Planning Officer: Mr Z Denton

Planning Application Ref: R/138/19/T

Location: 8 Elm Farm Cottages, Old Manor Road, Rustington, BN16 3FD

Description of works: Crown reduction to previous prune points including lower branches of 1 - 1.2m to 1no. bay tree

BAY TREE

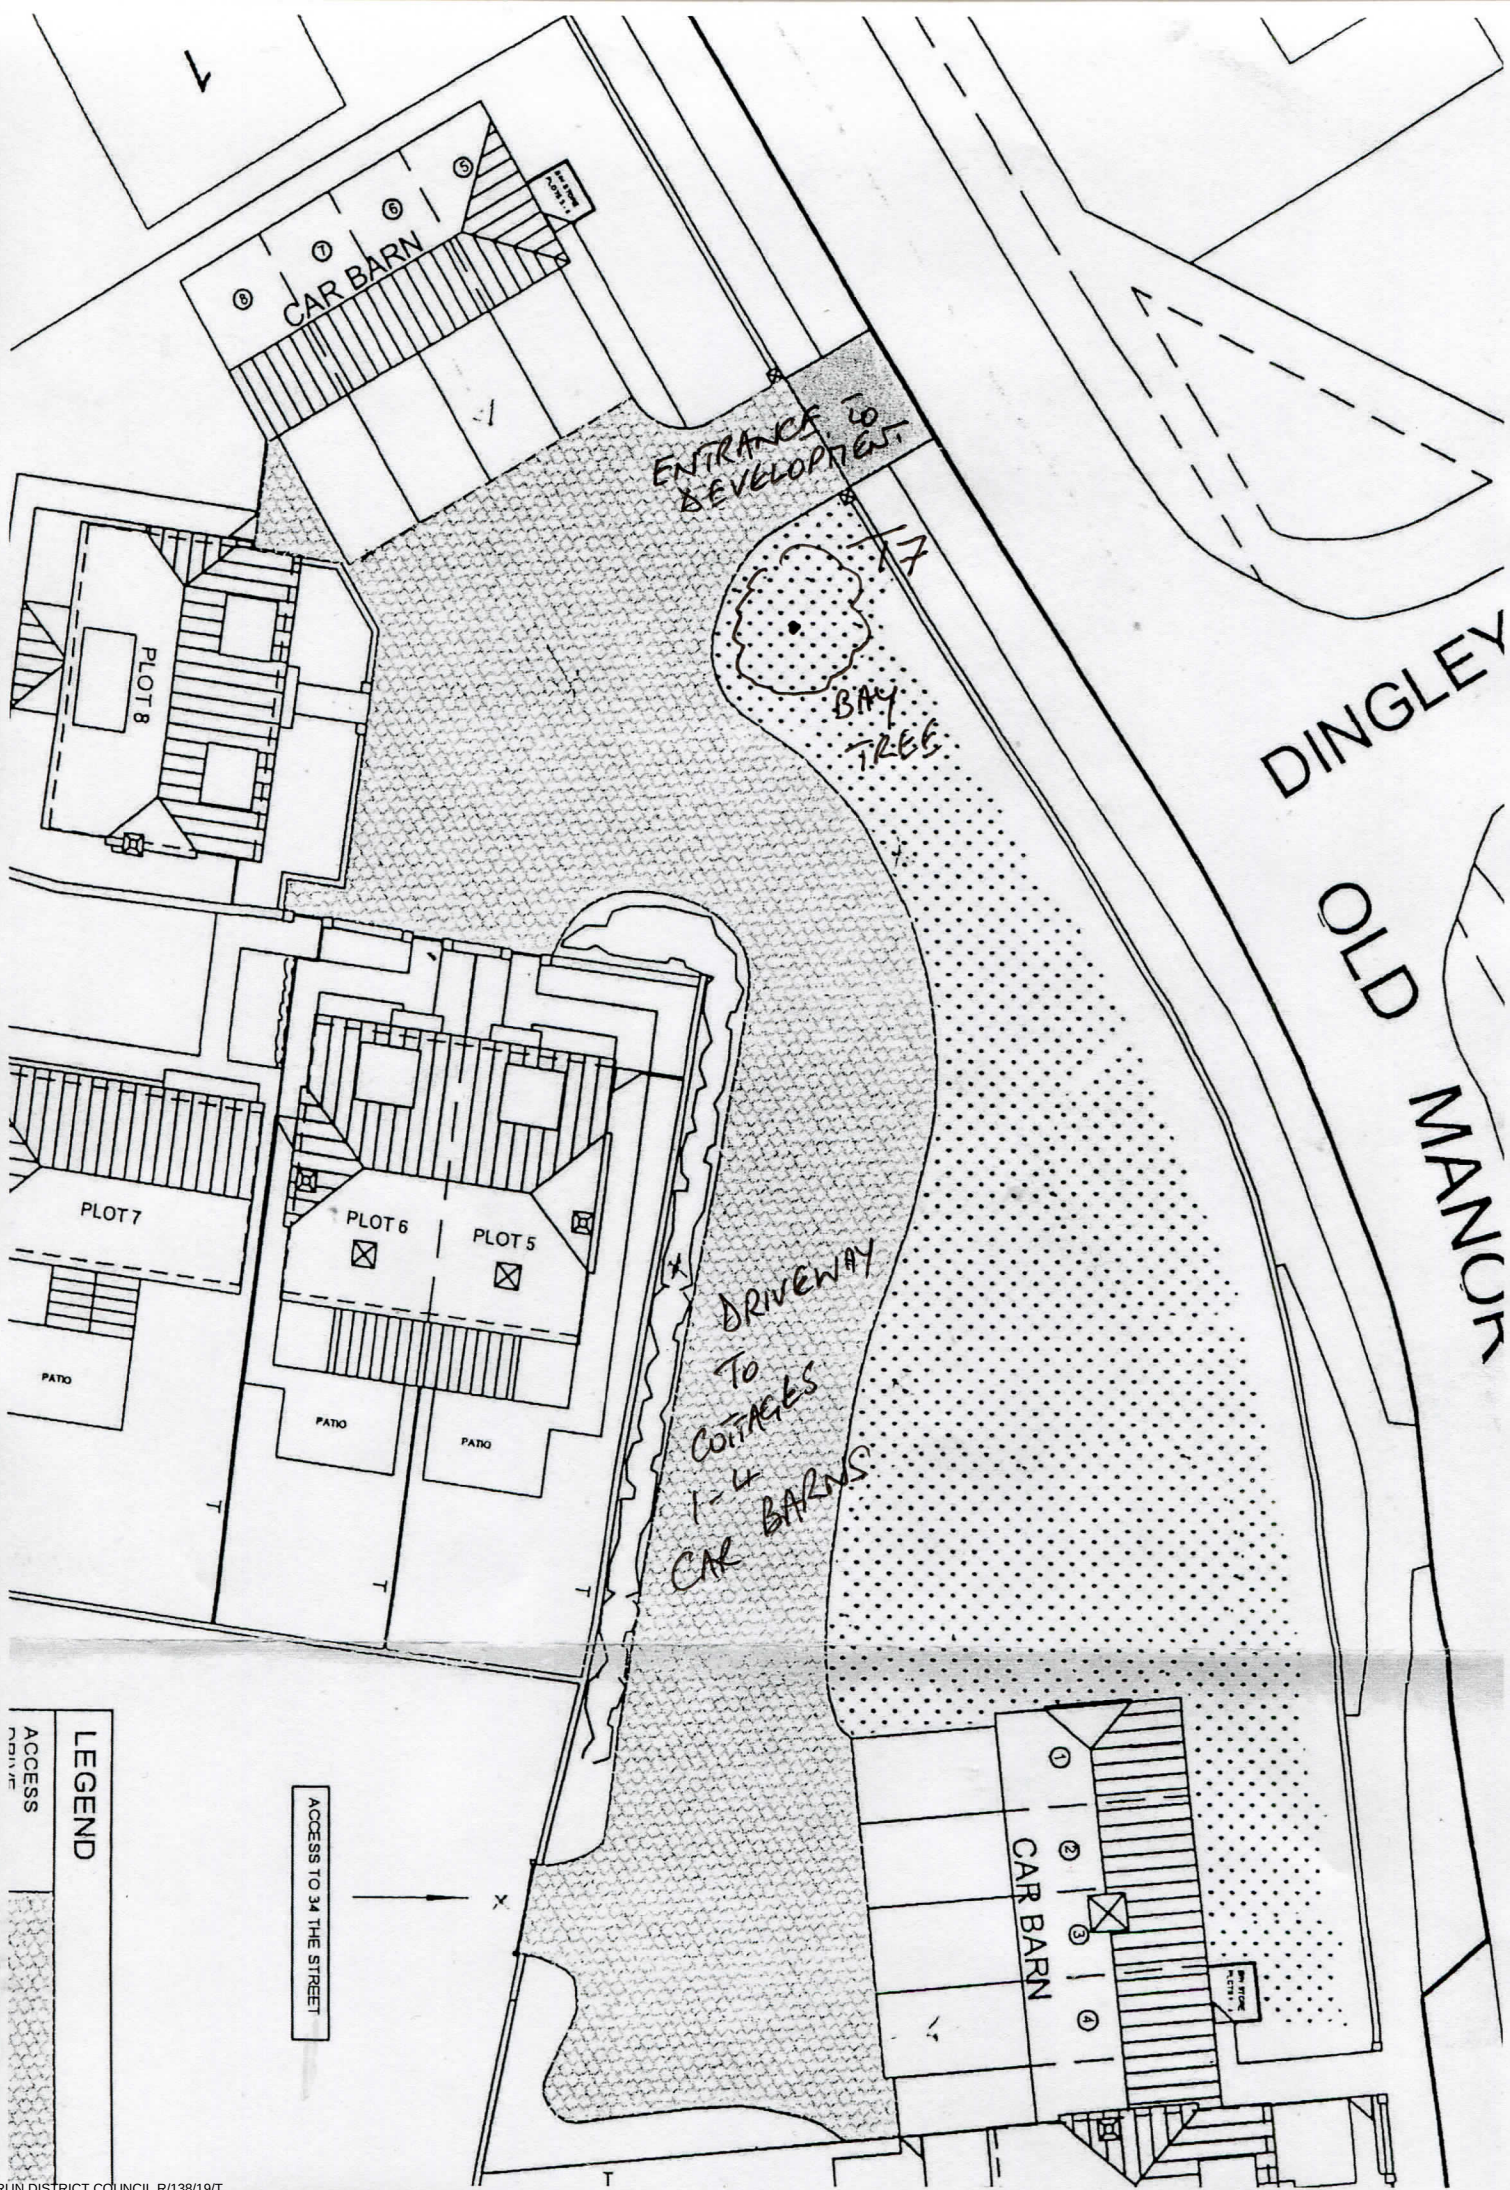
- This is a multi-stemmed tree of apparent good health. It has a heavily modified crown, resulting in a dense and compact form. It is visible from numerous properties and to users of the public highway (footway and carriageway).
- While this tree may add value to the garden it is of low amenity value and will require repeat pruning of the type proposed, to keep it in a structural state appropriate for its location.

- There will be no significant loss of public amenity on completion of the proposed works.
- The proposal to reduce its overall height and spread with a view to restricting its growth is justified and consistent with previous works approved by the Local Planning Authority.

- The removal of crown material which has developed since the last operation must be done sympathetically and with respect to established 'knuckles' so as not to extend beyond the point of origin.
- Where whole branches are to be removed and final cuts made close to the trunk or branch union they are to be made as shown in Figure 2 of BS3998:2010
- Where branches are to be shortened back the final cuts are to be made at the correct angle shown in BS3998:2010 and adjacent to a live bud or lateral.
